**From:** lindsey.lucas@hertscc.gov.uk  
**Sent:** 10 July 2012 16:03  
**To:** Planning  
**Subject:** Planning application N6/2012/1094/FP - 47- 49 Burrowfield

**Response to Planning application from Hertfordshire County Council (T and CP GDP Order 1995)**

**Location**  
 47- 49 Burrowfield  
 Welwyn Garden City  
 AL7 4SS

**Proposal**  
 Retention of new office building and security fencing and gates

Org.No: AT372-02

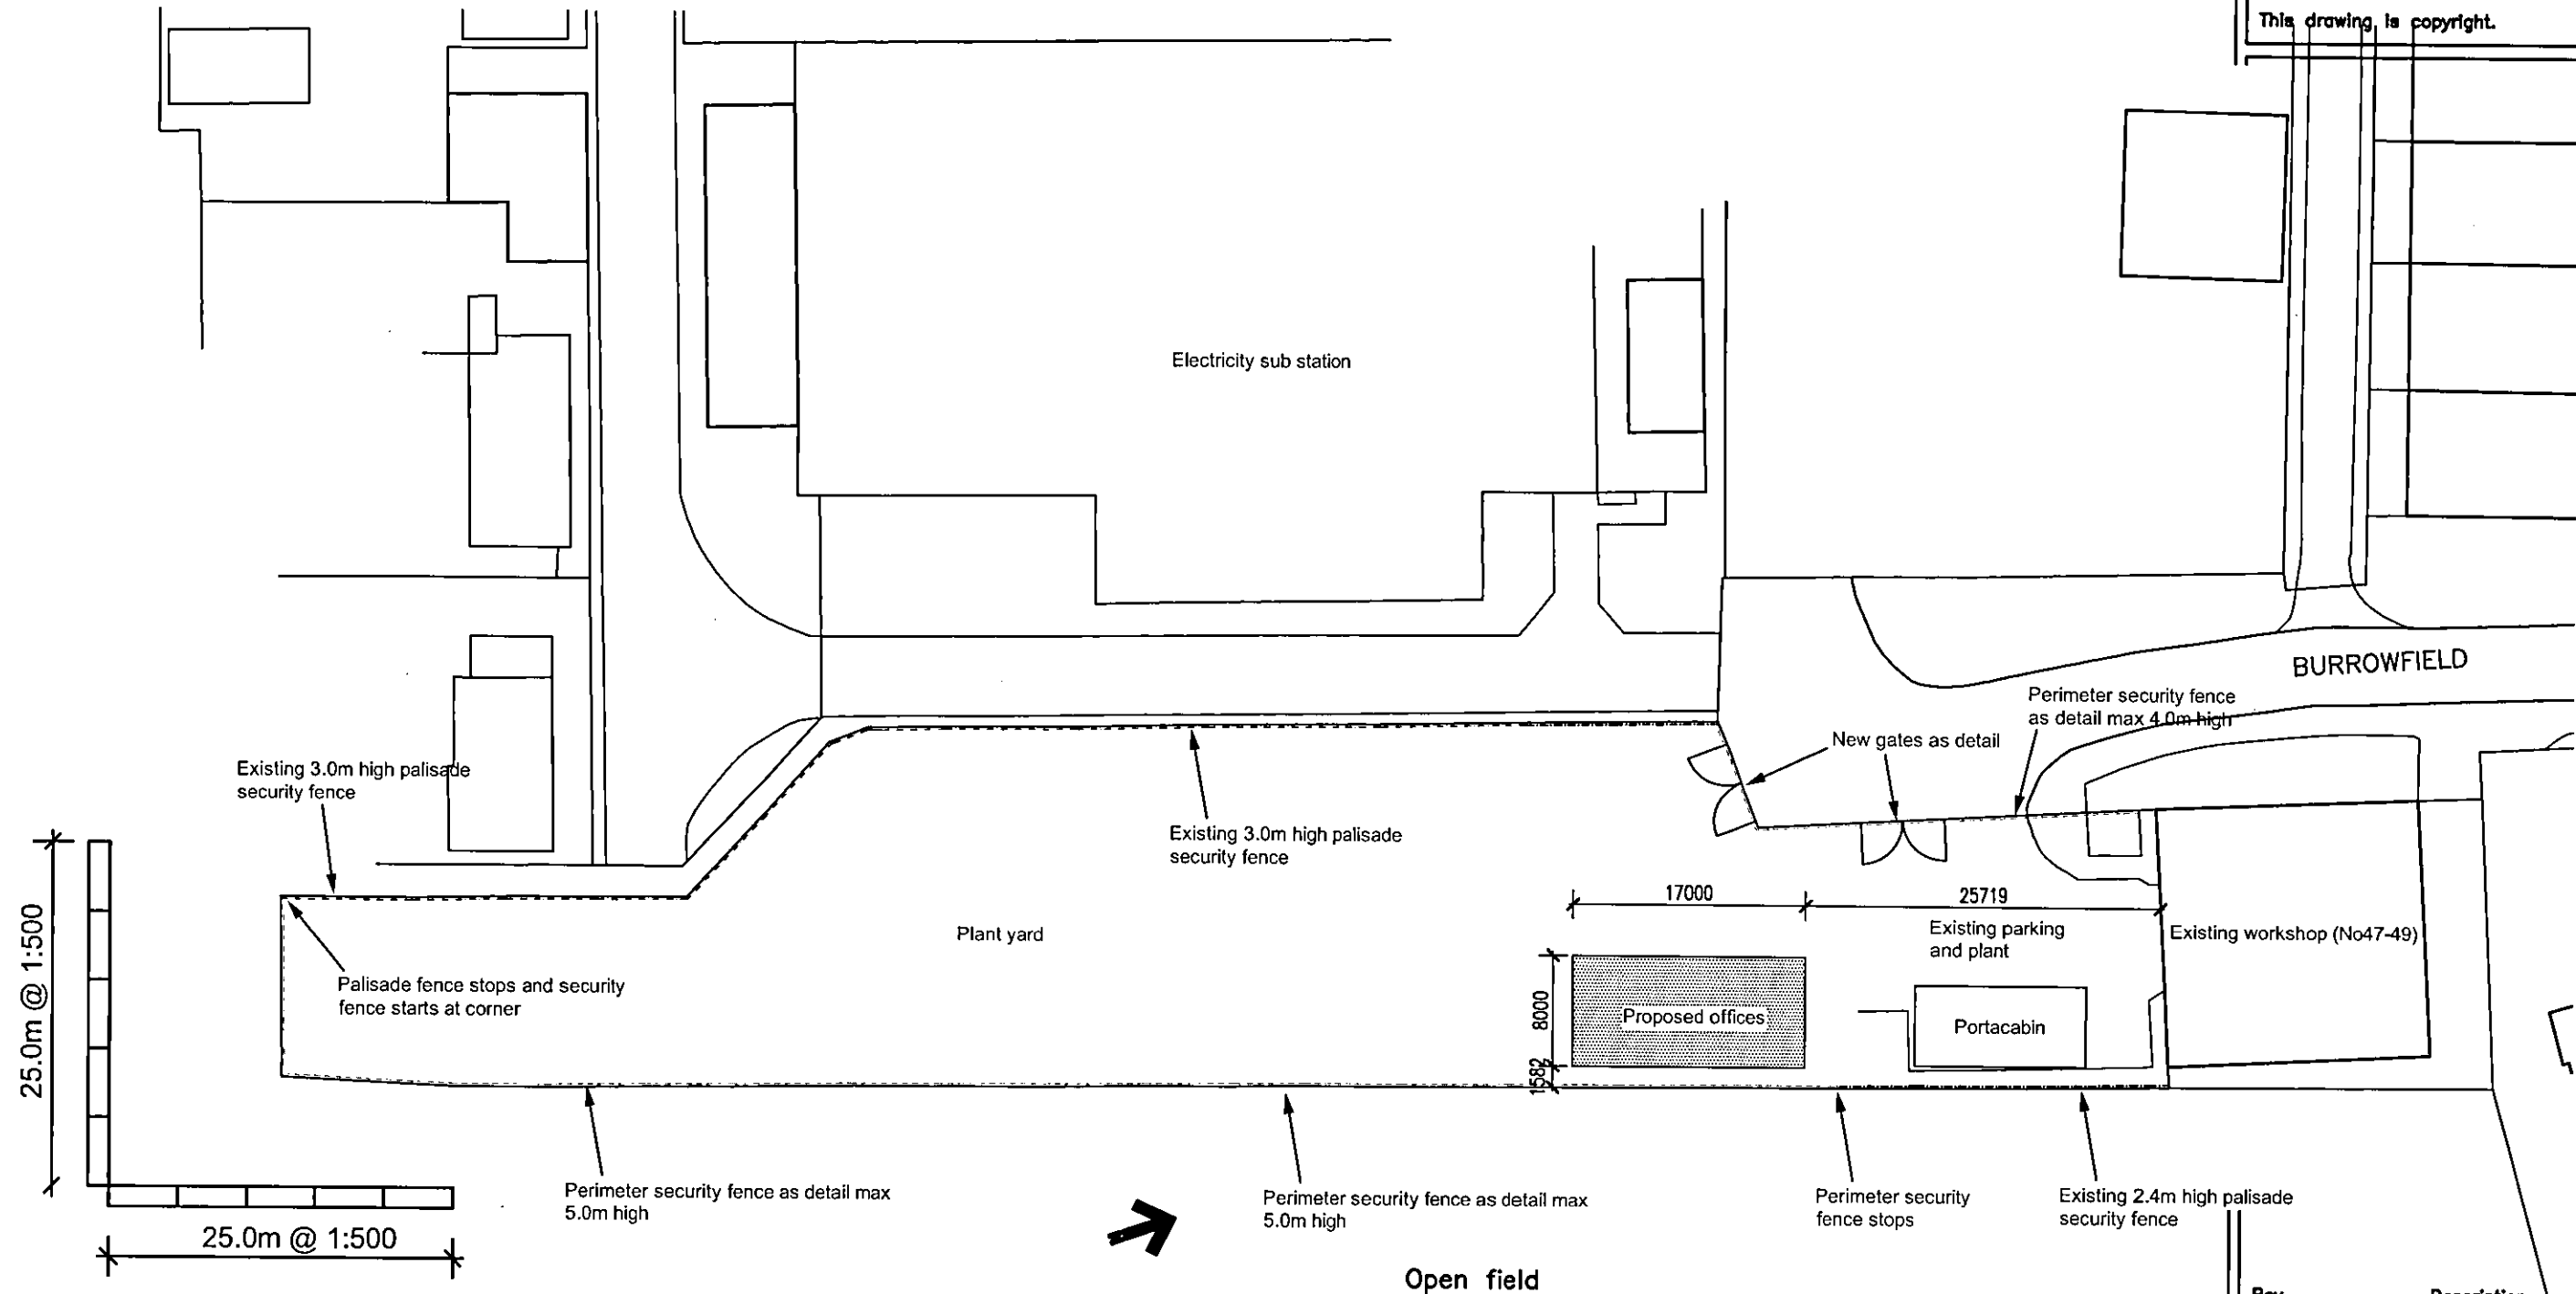
1. The area set aside for parking as shown on drawing number AT372-02A shall be laid out and surfaced before the development hereby permitted is first occupied and shall be retained permanently there after for the parking of staff and delivery vehicles operating from the site and shall not be used for any other purpose.

The proposal is for the retention of new office building and security fencing and gates. Burrowfield is a local access road and serves a number of industrial properties. Although the Design and Access statement states that there is space on site available for parking, no parking layout plan was originally submitted as part of the application. From my site visit I also noticed that cars park perpendicular to the building marked as "existing workshop" on the Site Plan number AT372-02, however there is no dropped kerb to serve these parking spaces and if they are to be included as part of the parking provision for the site then a dropped kerb should be provided.

A revised site plan AT372-02A has now been submitted and this shows parking for 8 mixer trucks, 8 staff cars and 2 visitor spaces. These are all contained within the site and sufficient manoeuvring space is retained to enable vehicles to enter and leave the site in a forward gear. Providing the site is laid out as

shown on this revised plan, the proposals will not impact on the surrounding highway network. The proposal will not result in a significant increase in vehicle trips to the site.
